Recommendation Report for Planning Permission for Works or Extension to a Dwelling

REF NO: BE/50/21/HH

LOCATION: 1 Babsham Cottages
Babsham Lane
Bersted
PO21 5EL

PROPOSAL: Two storey side extension including alterations to roof

sheet 1 of 3

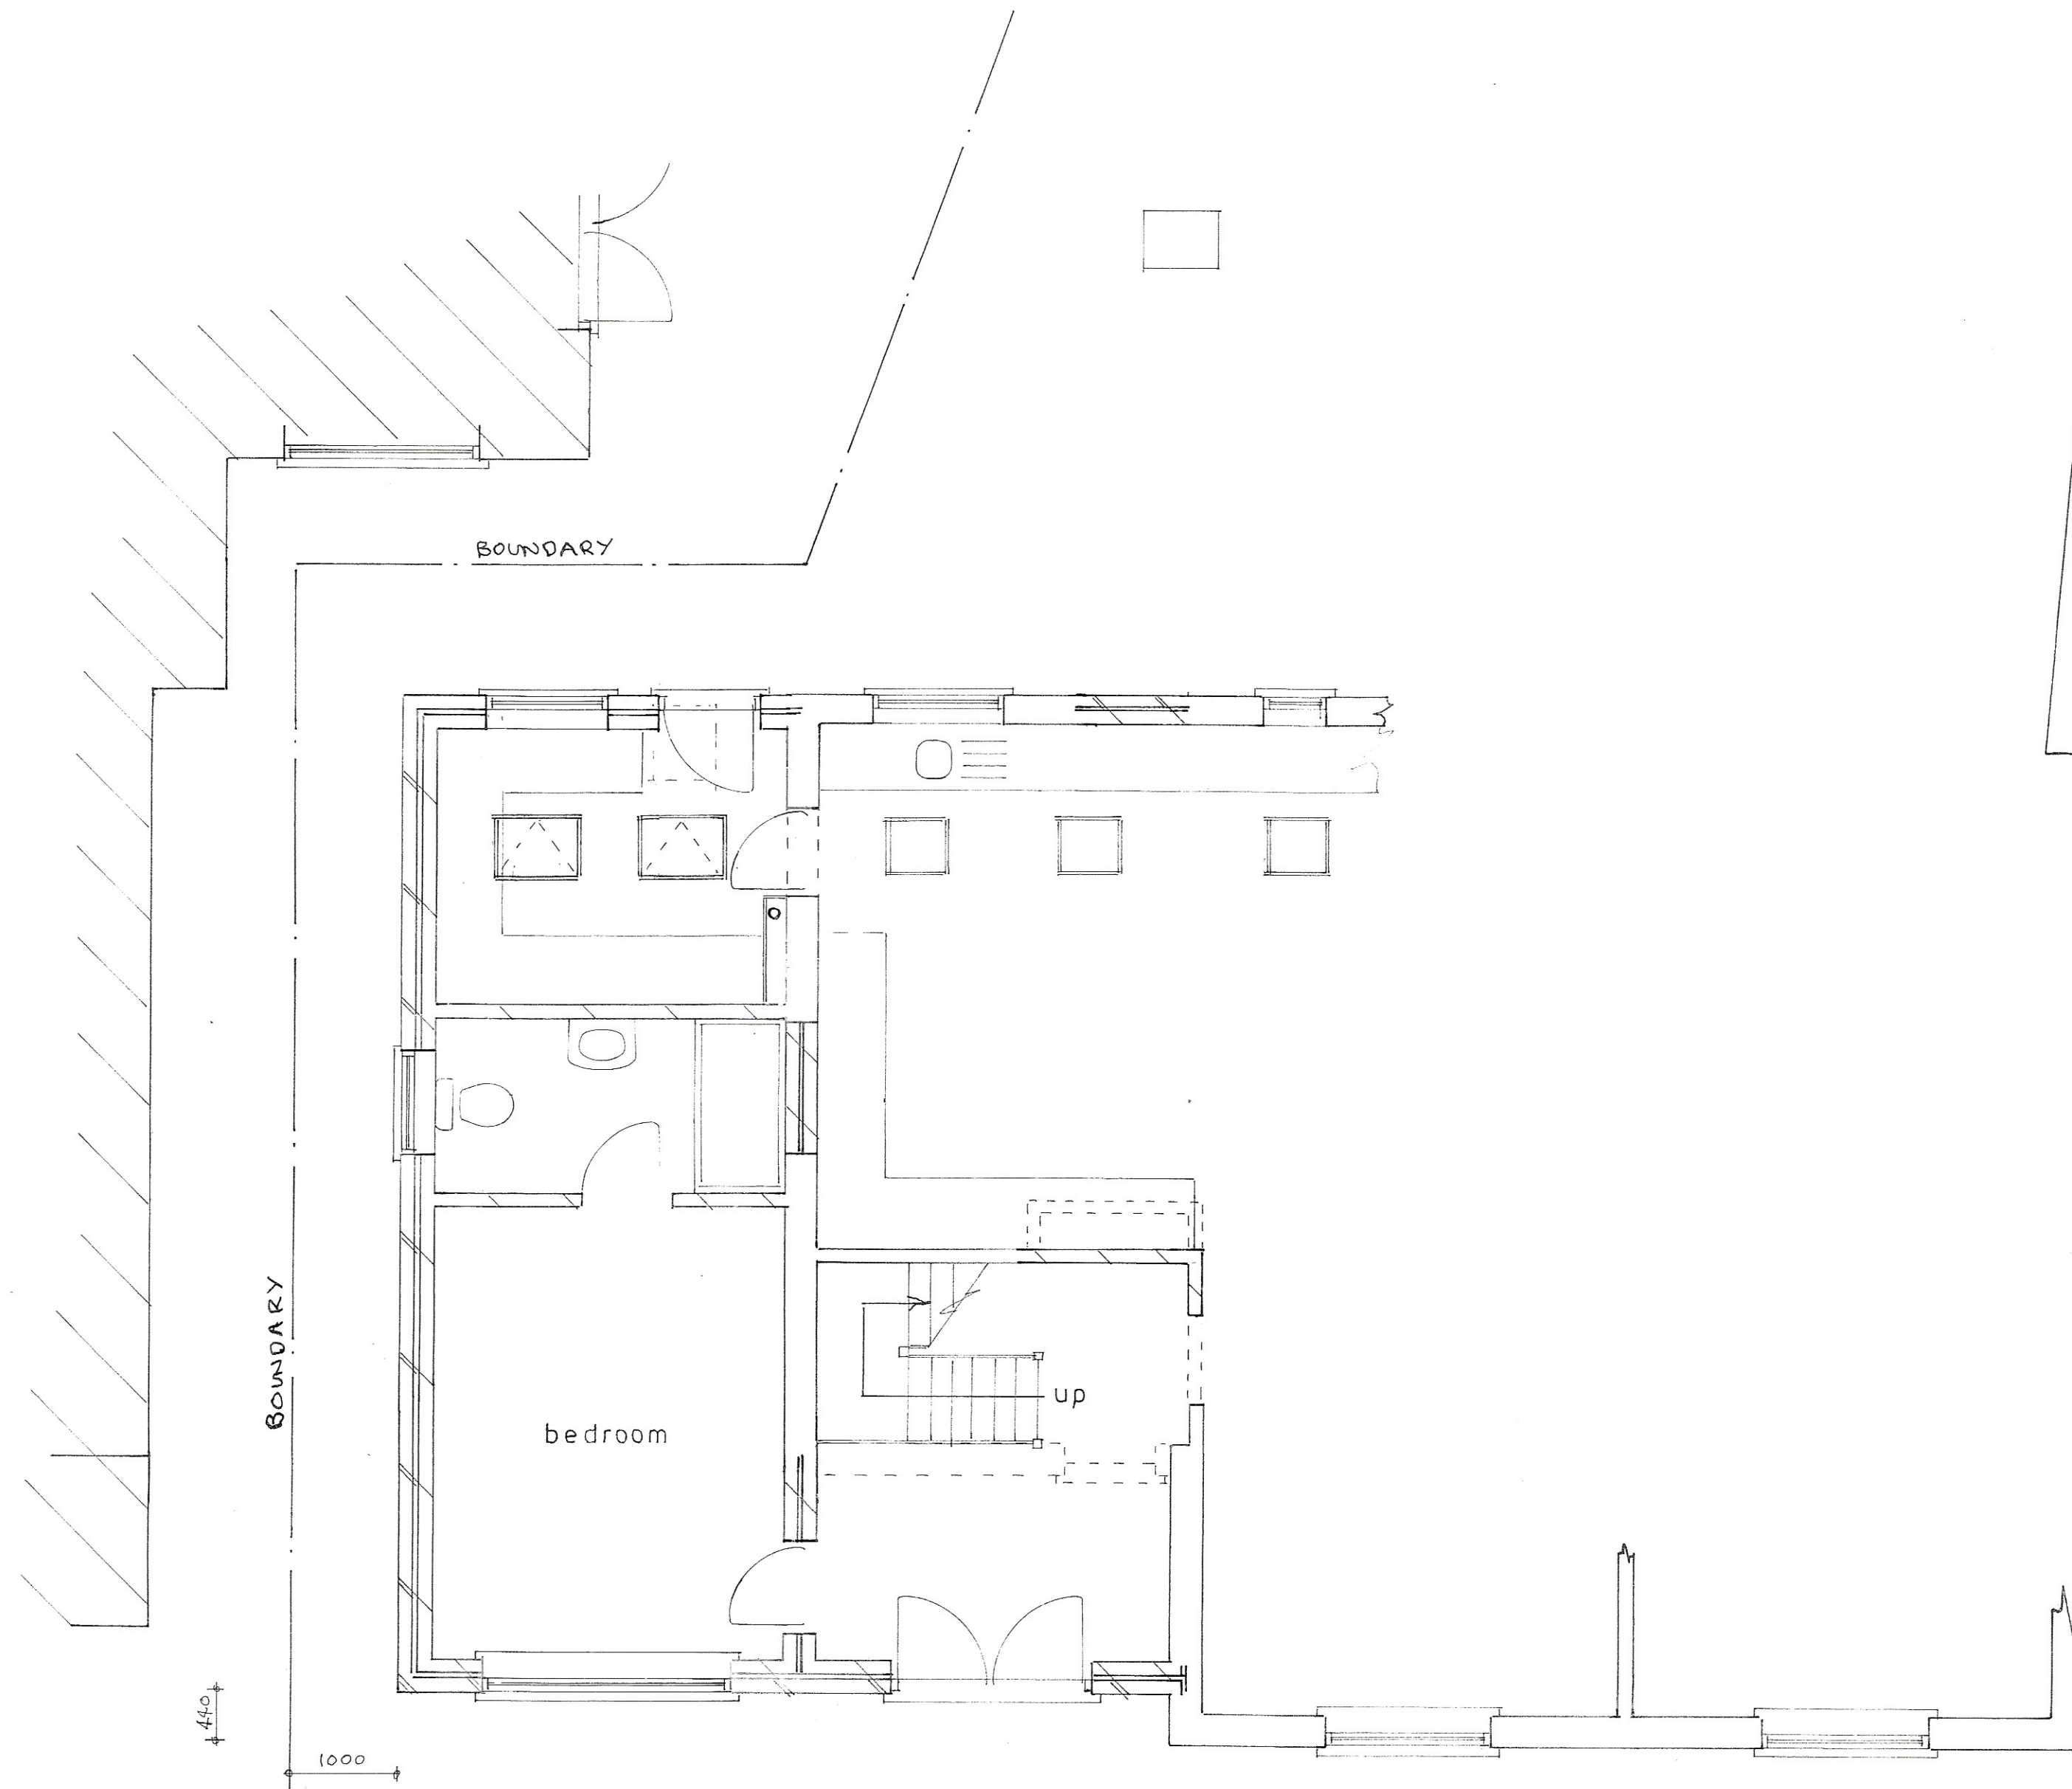
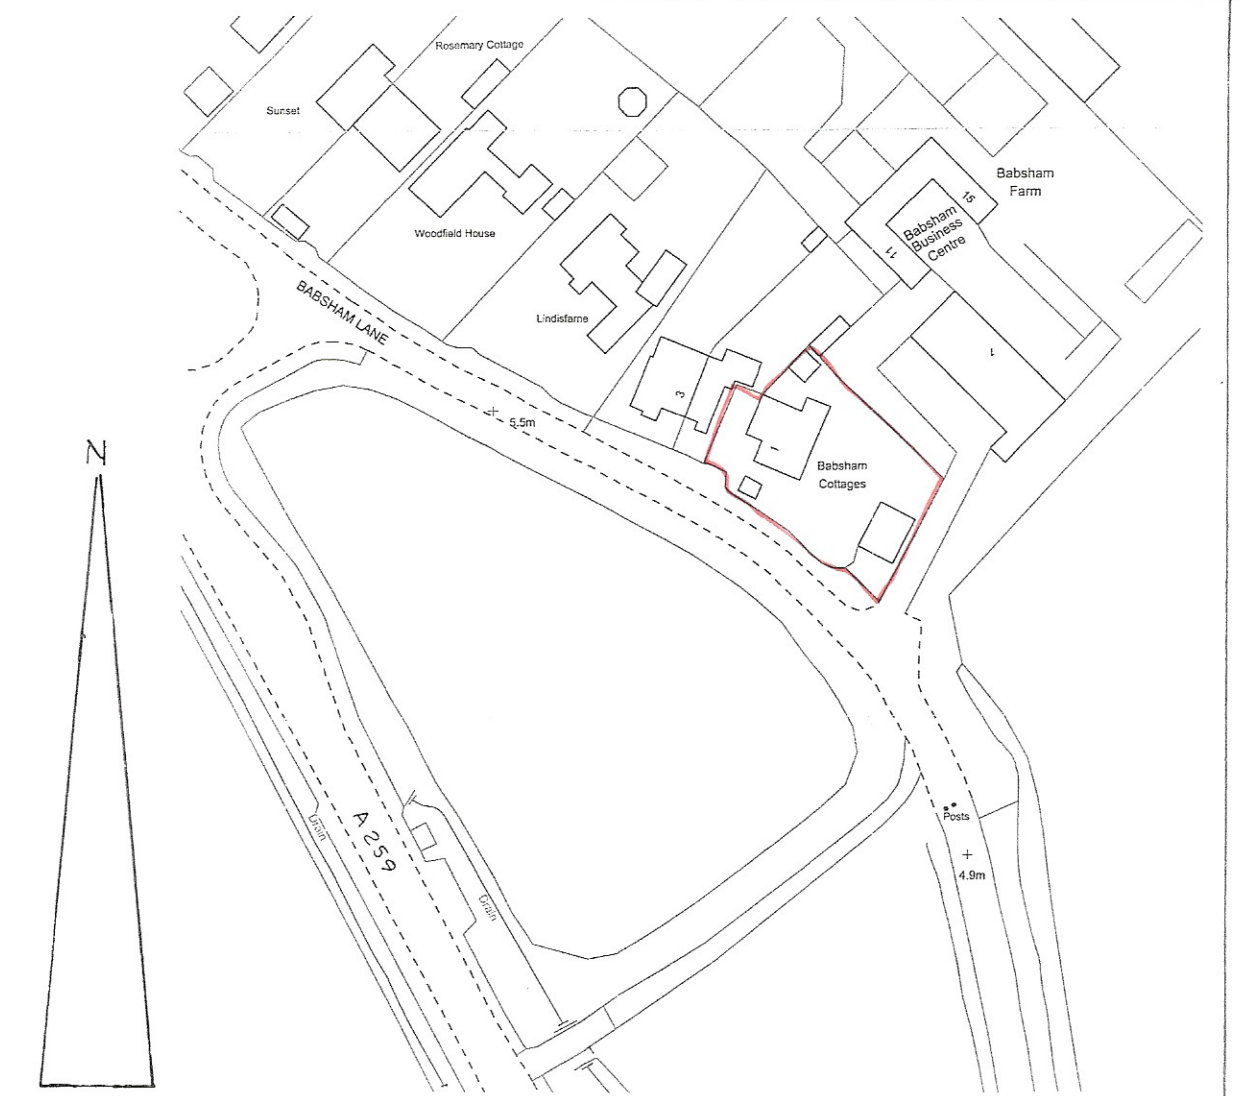
The extension does not extend beyond the principal elevation and retains 1m to the side and 4.2m to the front boundary.

The rear single storey element will have a lean to roof, which will join with an existing rear addition, matching in height. The development will feature 1 side window to the ground floor which will serve a bathroom and a window facing the rear serving a utility. This replaces an existing window and due to the siting, views are not considered to increase from that which are already available from standing in the rear/side garden.

sheet 2 of 3

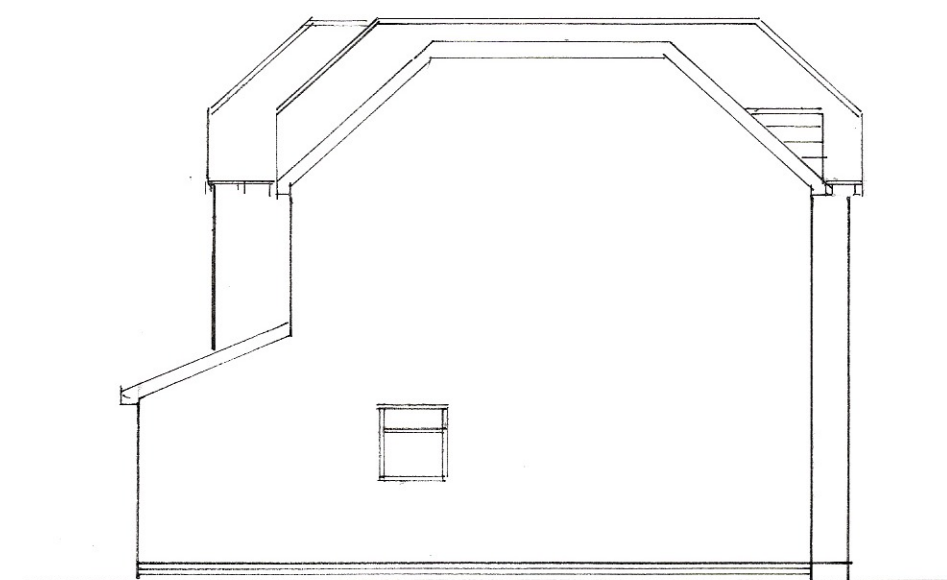
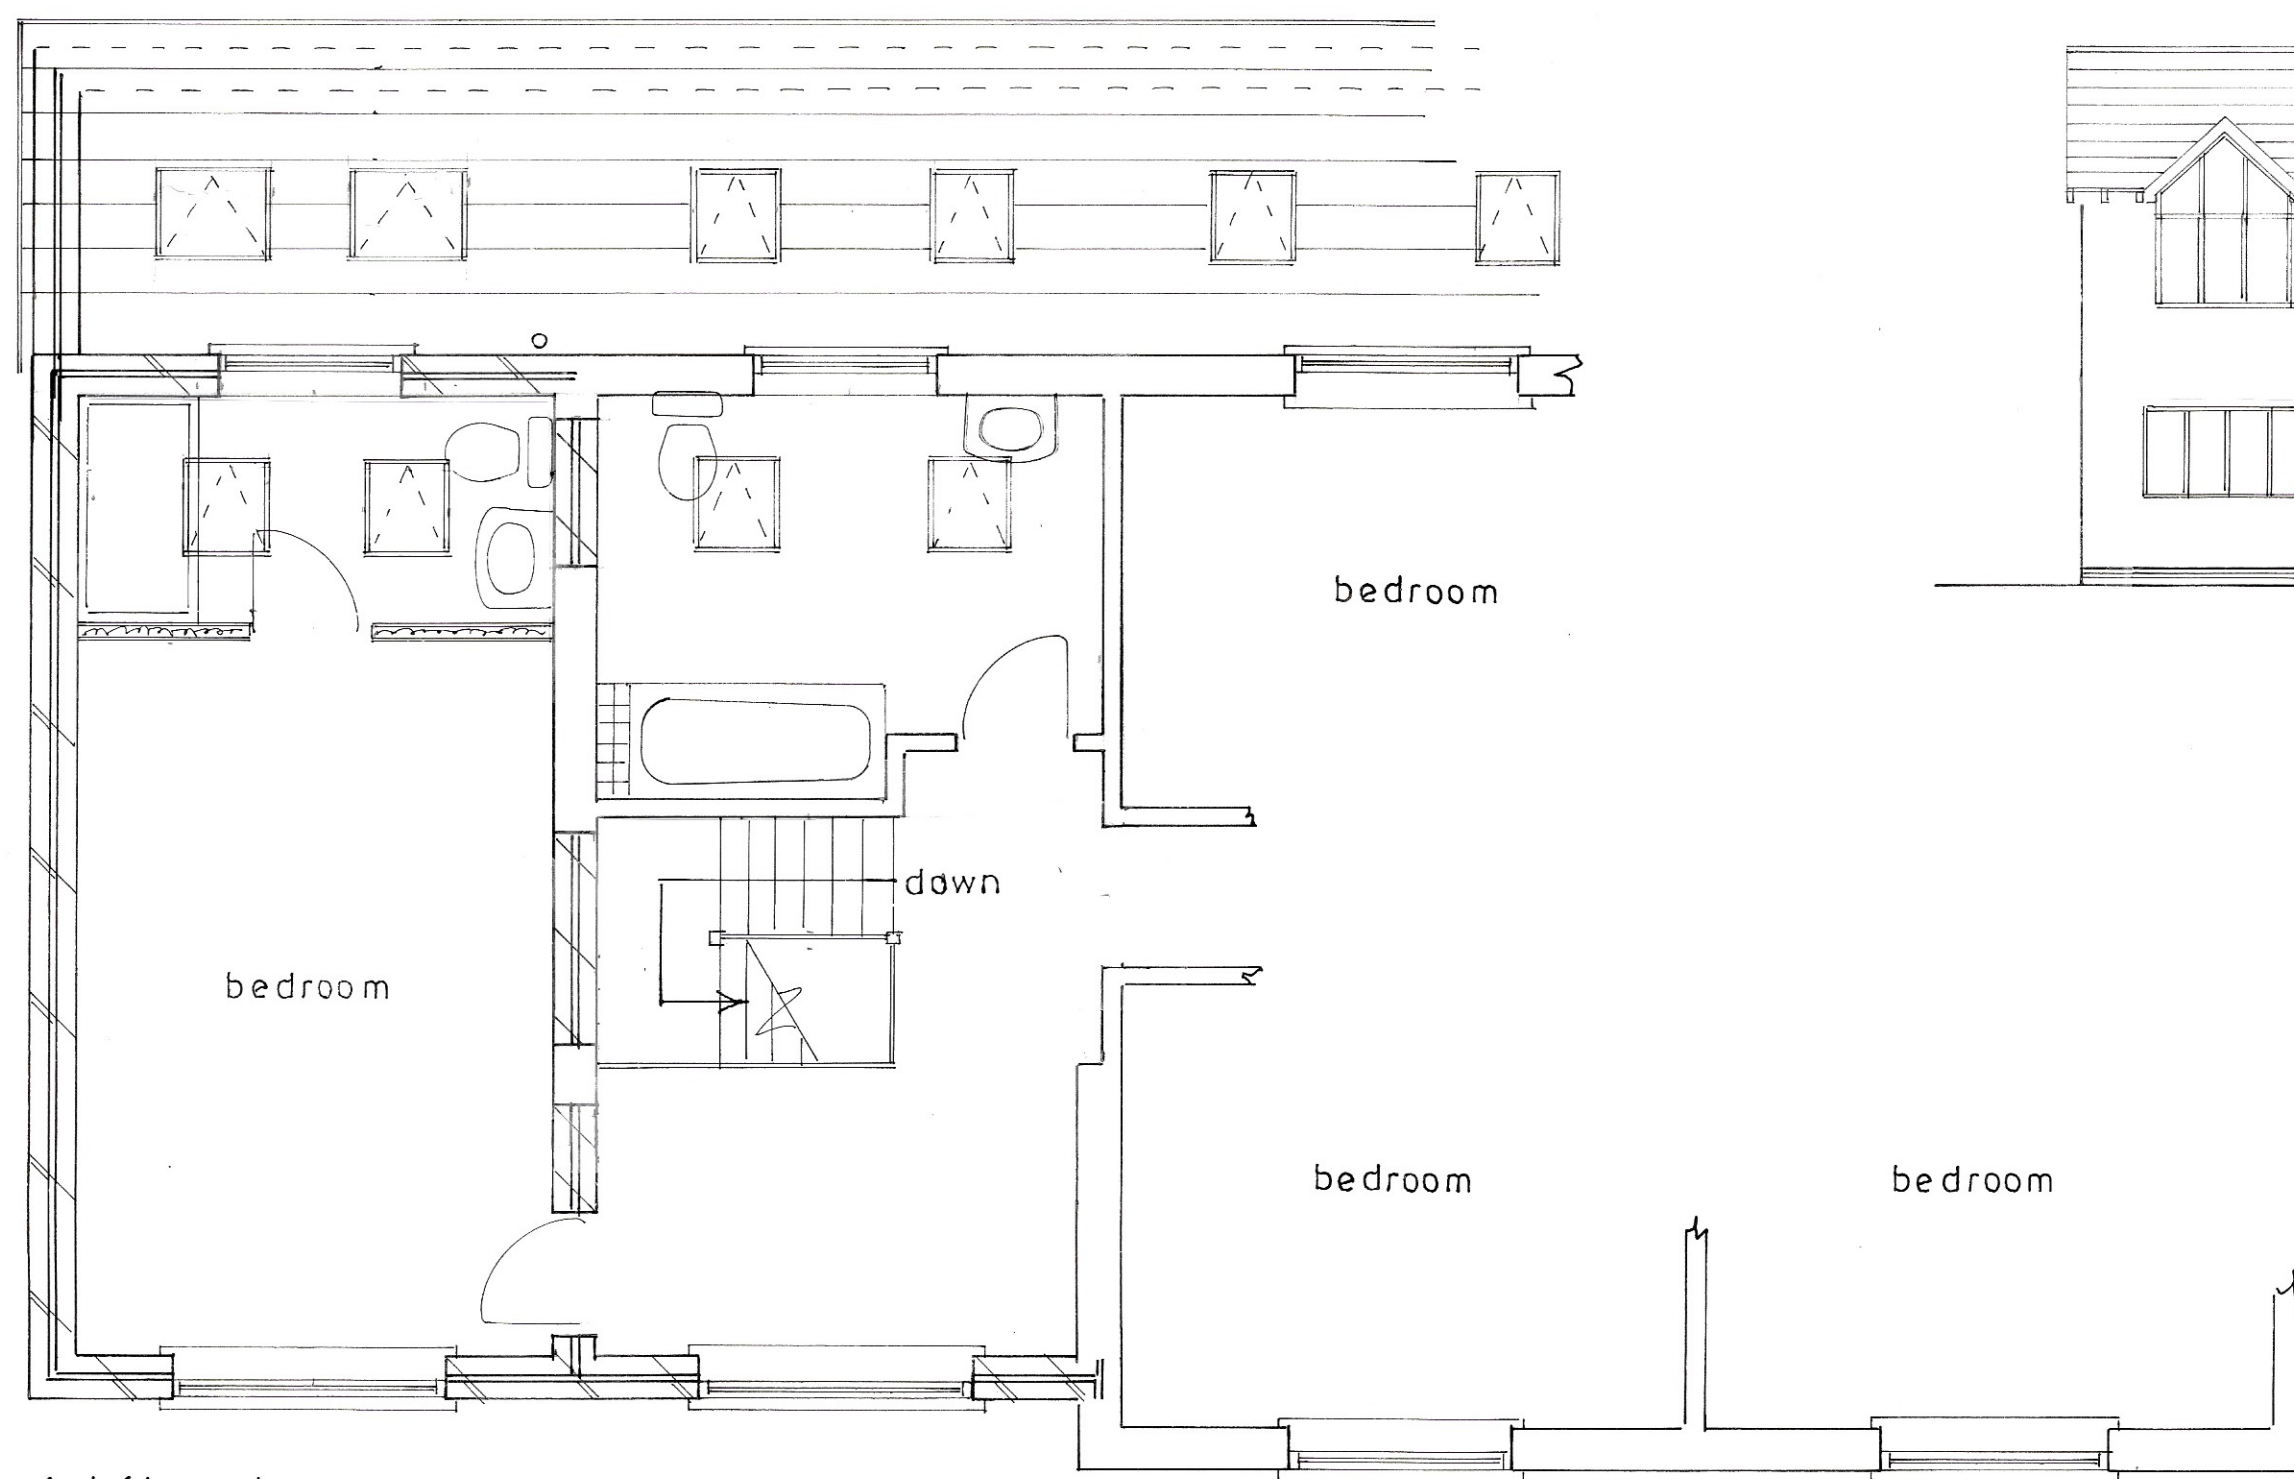
The addition will extend west infilling part of the front elevation which currently features a covered porch area and runs along the side elevation where it will reduce to single storey to the rear. It will have a flat pitched roof with a height of around 7m, similar to that of the host dwelling.

The extension will add bulk to the property and as such does not appear as a subservient addition in conflict with D DM4 (b) however it will consist of material to match existing to ensure its integrated with the appearance of the host dwelling. It features 2 large gable windows which appear sympathetic in design to the front elevation of the main dwelling.

The extension will retain 1m to the western boundary and neighbouring dwelling. The two storey element will extend along the front and side elevation for around 6.8m where it will reduce to single storey for 2.2m.

To the first floor there will be an additional rear window facing north. Due to the shape of the boundary and location of the neighbouring property, this may give rise to some overlooking. However as the window serves a bathroom, it will be conditioned that it remain obscured glazed. This will ensure it does not give rise to adverse views upon the neighbouring property gardens.

- 3 The first floor window to the rear elevation of the building shall at all times be glazed with obscured glass and only openable at a high level, at least 1.7m above finished floor level.
